# Outer Dowsing Offshore Wind

## The Applicant's Comments on Natural England's Risk & Issues Log

### Deadline 4

Document Reference: 21.8

Environmental Statement  
 Designated Sites of relevance to  
 Marine Physical Processes  
 Figure 7.9

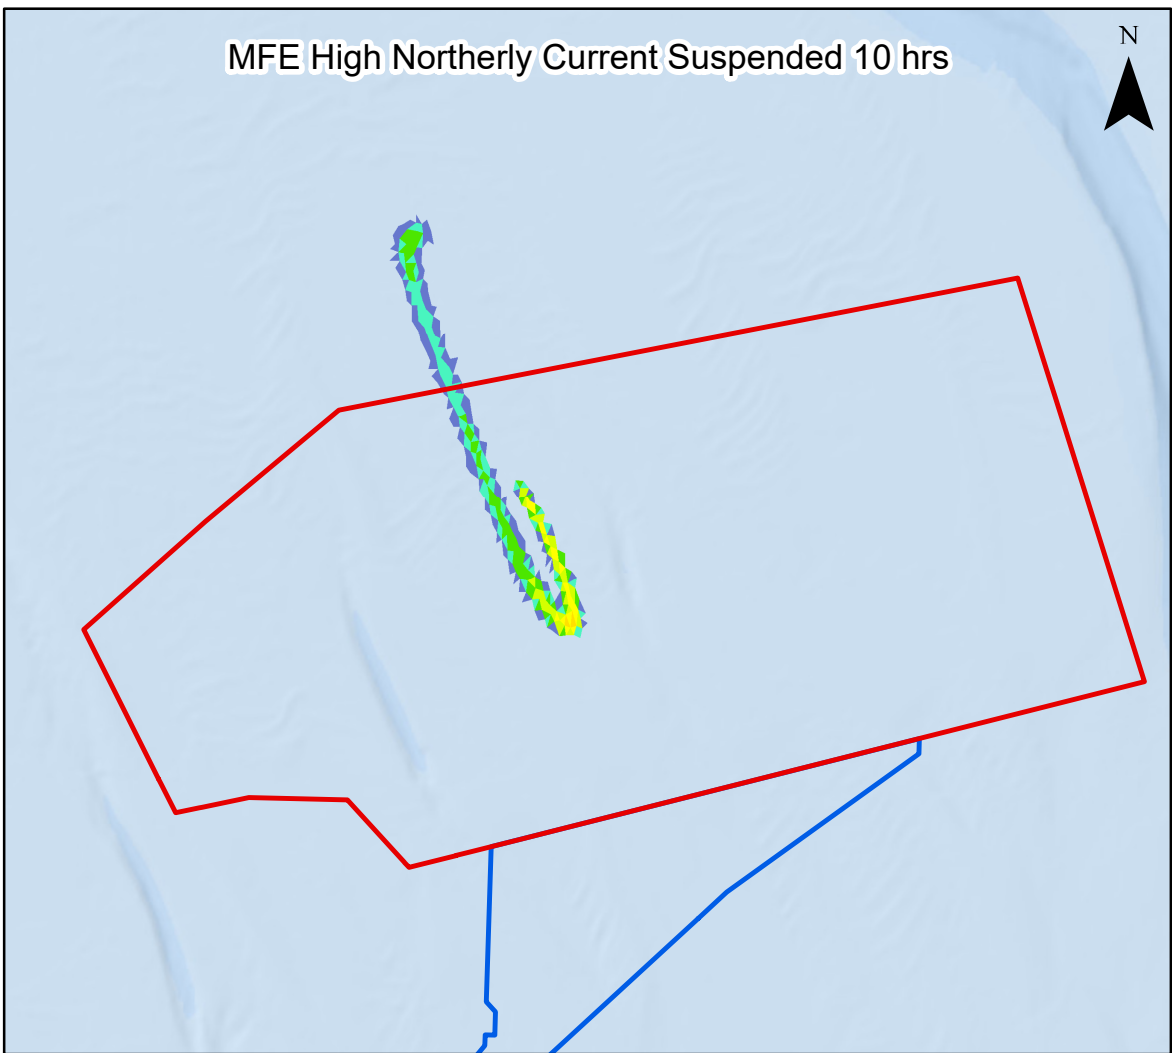
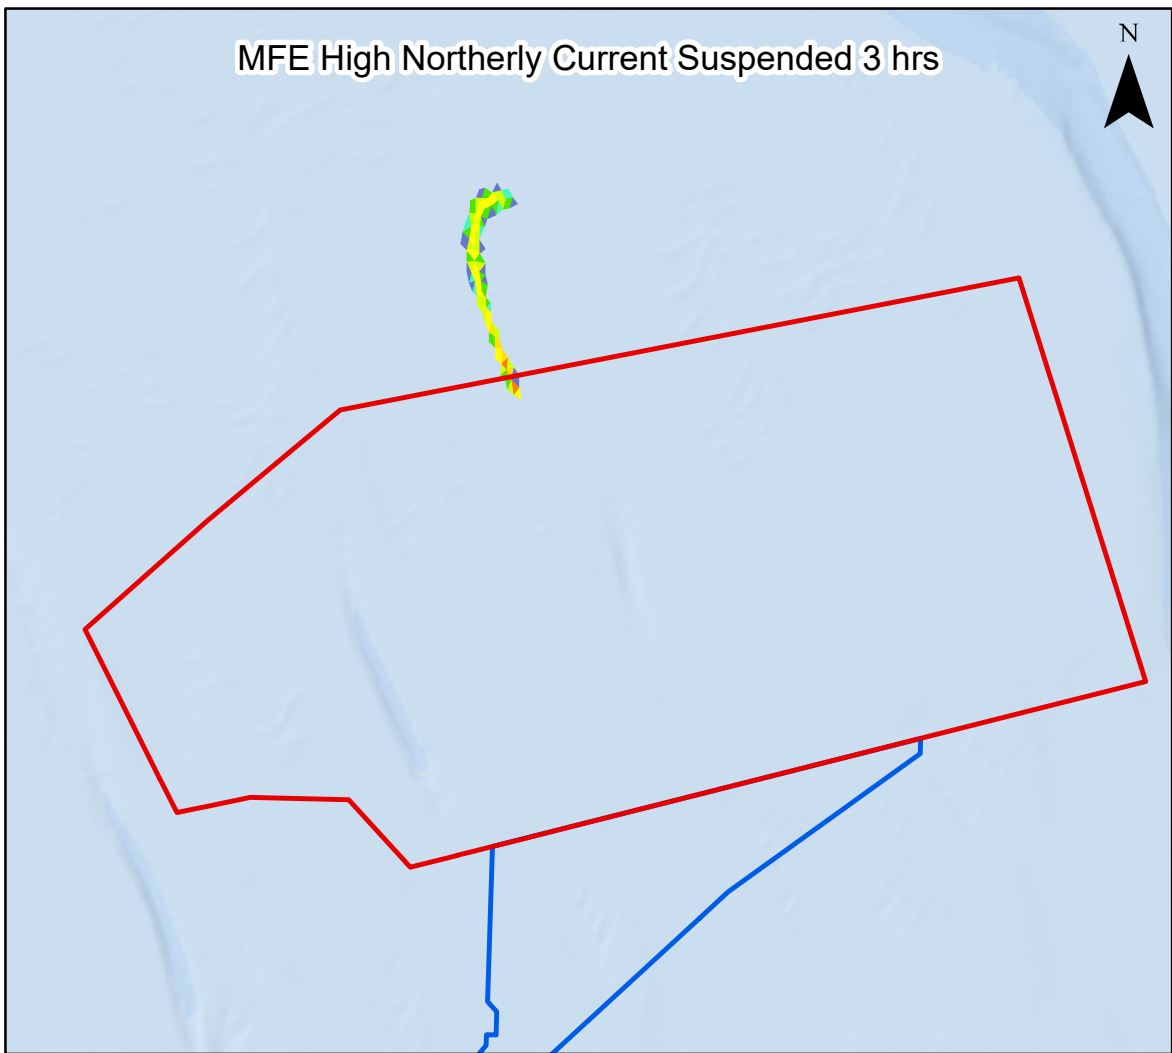
10	B16	Inner Silver Pit glacial tunnel valley has not been included as a receptor in [APP-062]. Natural England advises that further consideration of the potential impacts of the Project on Inner Silver Pit is required.	D1 - Issue resolved. The applicant has confirmed in their response this has been assessed in APP-062 and APP-065.	
11	B17 & B2	Is the scheme layout modelled presented in Figures 7.24 to 7.26 actually the realistic WCS, or whether, based on the engineering assessment [APP-152], the realistic WCS is more likely to be a scheme layout where foundations are located away from mobile sandbanks and the larger sandwaves. Further clarification/evidence from the Applicant on hydrodynamic and wave modelling of RWCS inline with the Seabed Mobility Report.	D1 - No change. Please see our Deadline 1 Appendix B1 and comments made in response to the additional modelling carried out due to the changes to the array (and introduction of the ORBA). D2 - Our advice remains unchanged since Deadline 1. D3 – No Change	The Applicant has provided a response in Row B17 and B2, Table 1.45.3.2 of the Applicant's Response to Relevant Representations (PD1-071), and has provided further clarification in B1.2, Table 2, The Applicant's Comments on Deadline 1 Submissions (REP2-053).  In accordance with paragraph 2.6.2 of NPS EN-3, the potential windfarm layout as presented in the numerical modelling represents the most realistic Worst-Case Scenario (WCS) based on the currently available information. A figure showing the assessed layout has been provided as part of the Environmental Report for the Offshore Restricted Build Area and Revision to the Offshore ECC (PD1-081). The Applicant considers the modelled layout to appropriately represent a realistic WCS for the purposes of assessment for Marine Physical Processes receptors.
